Subject: FW: Clerk Laithe Farm Shop 2020/0933

From: Bloomer, David
Sent: 25 November 2020 14:09
To: Stephen Kilmartin
Subject: Clerk Laithe Farm Shop 2020/0933

A1.3

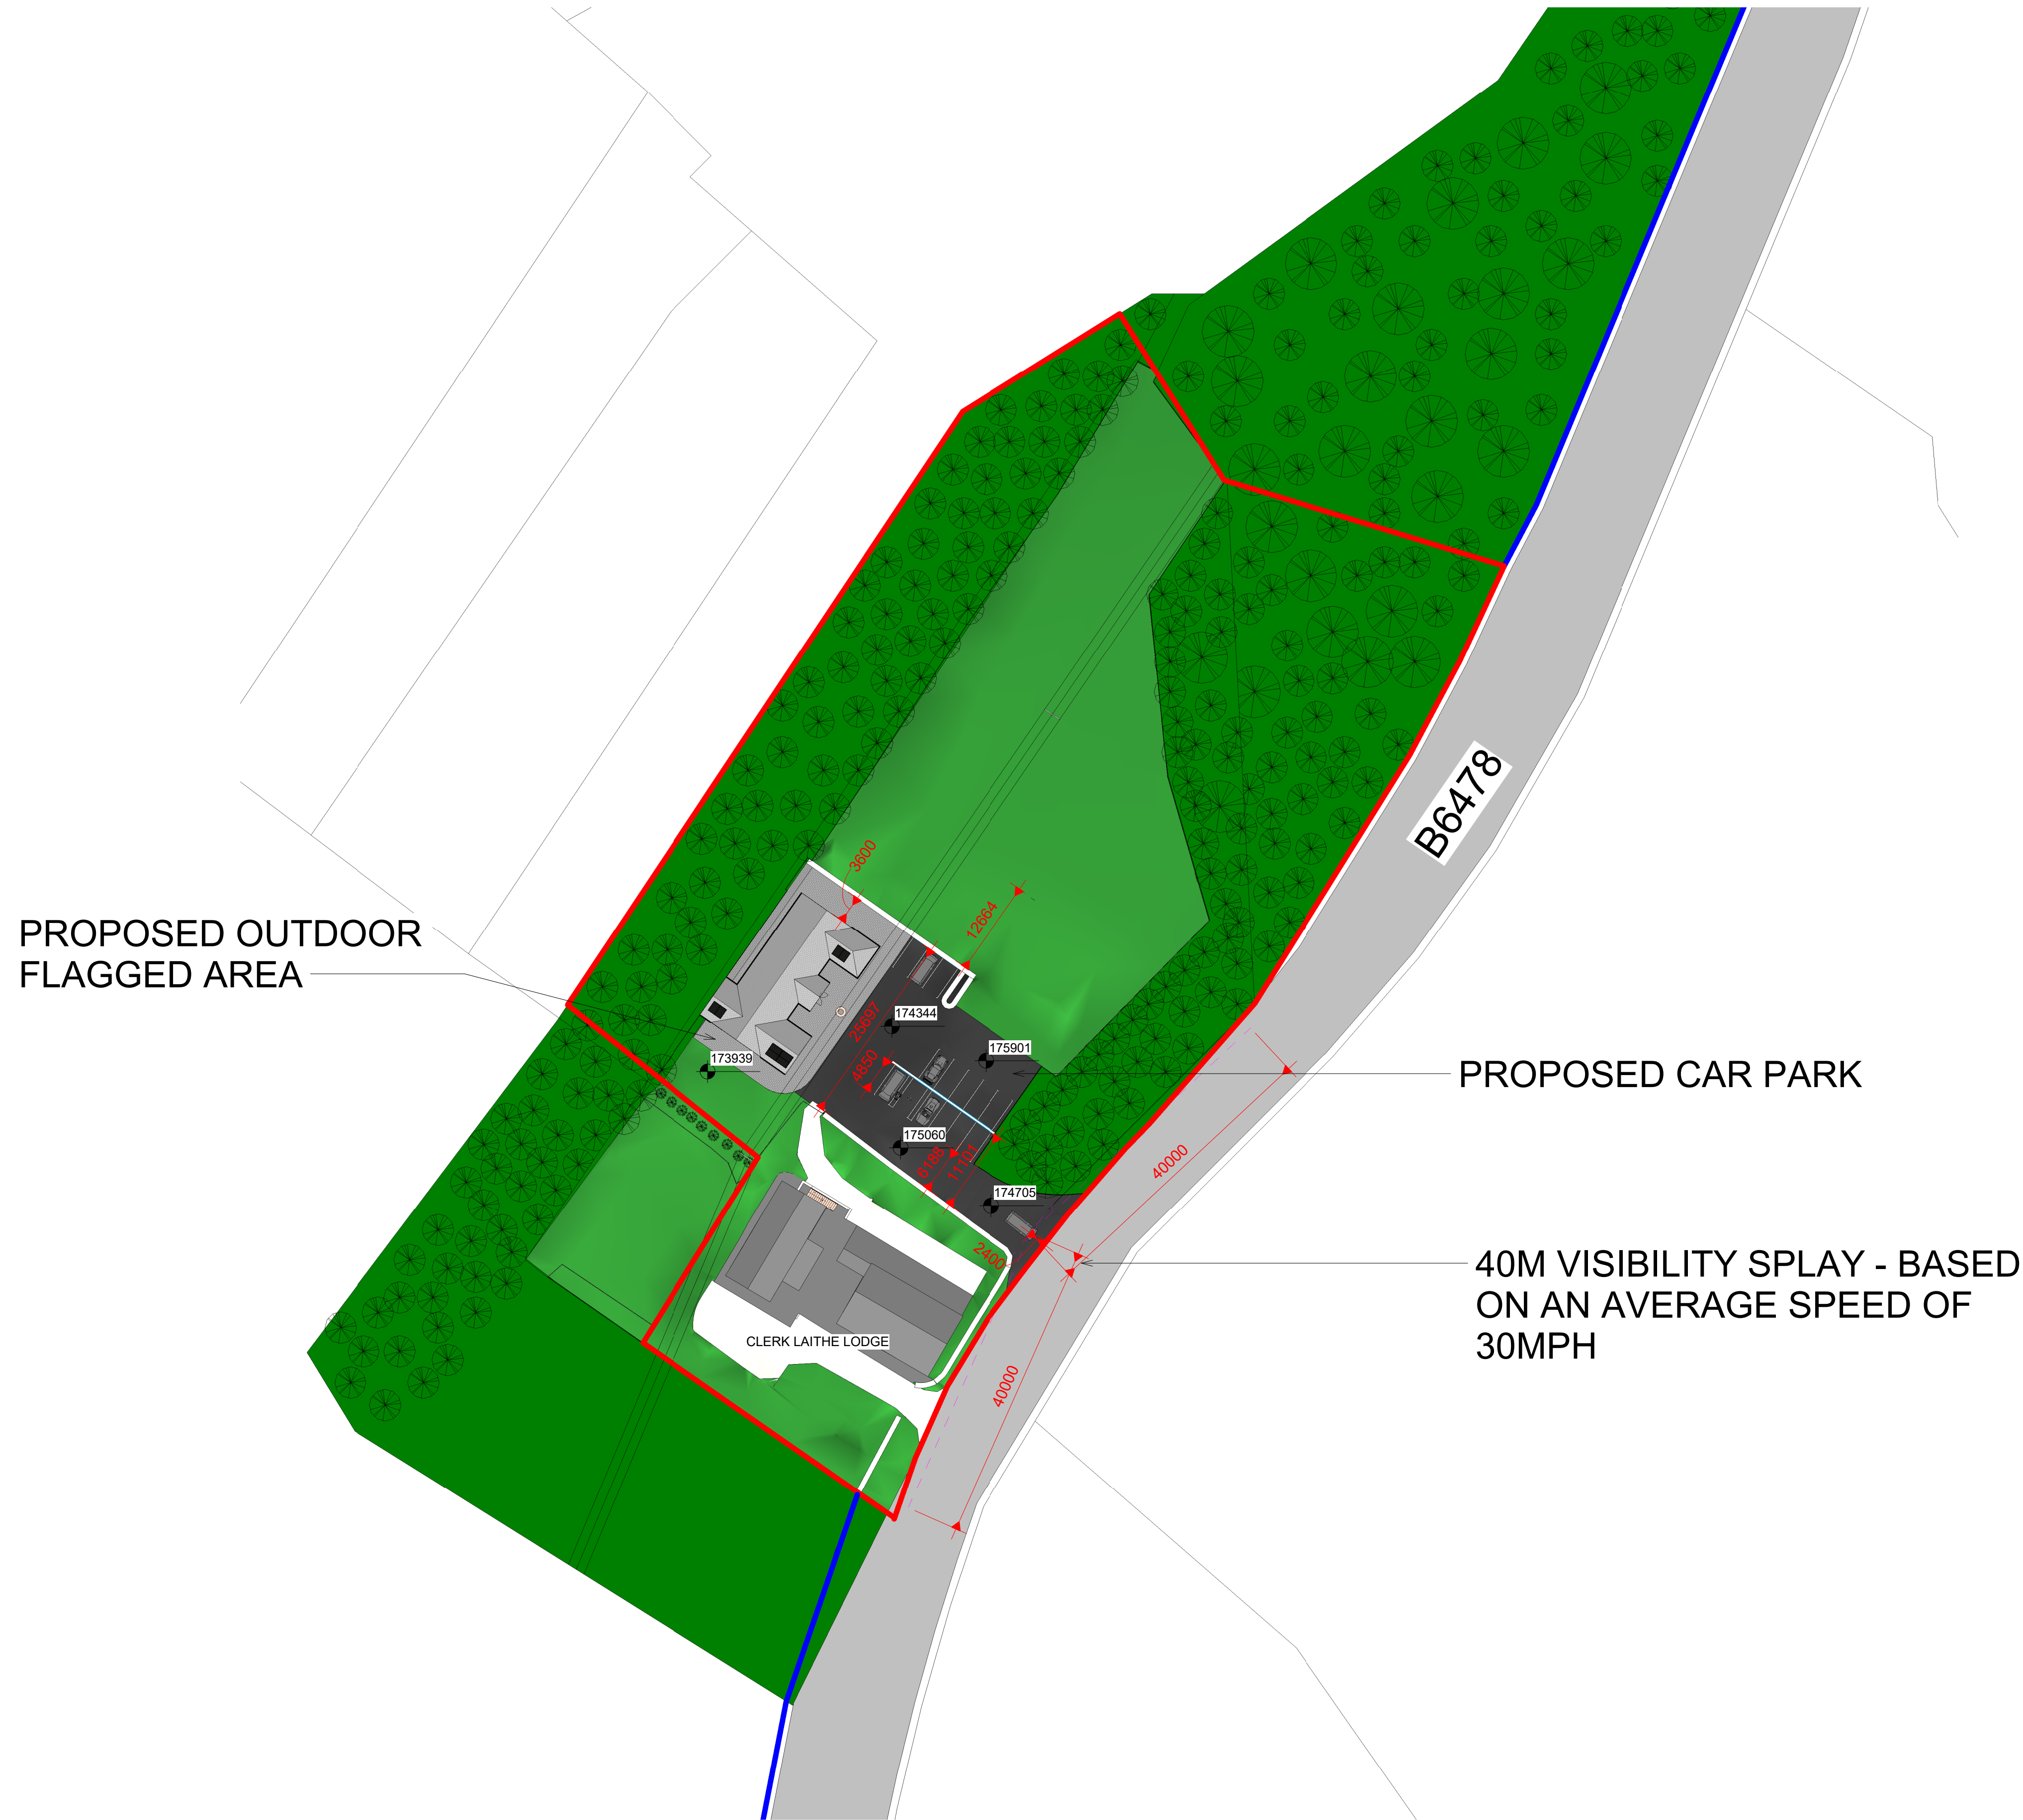
Reason 4 Visibility splay at the site access. In my response to the previous application I did state that in the absence of any evidence to the contrary the visibility splay requirements would be determined by the posted speed limit which in this case was 60mph - requiring a 2.4 x 215m visibility splay in either direction. I went on further to suggest that the visibility requirements could be reduced based on the 85thile speeds. Unfortunately the applicant has not provided any evidence that would support the relaxation of the visibility splay and until such time as this is presented I would be recommending a refusal in my formal comments.

In respect of the visibility splay shown on plan ref A1.3 this is , at 40m, less than the 70m stated in the 20/0444 application and it assumes an average speed of 30mph . Visibility splays dimensions are based on the 85thile speeds not the average
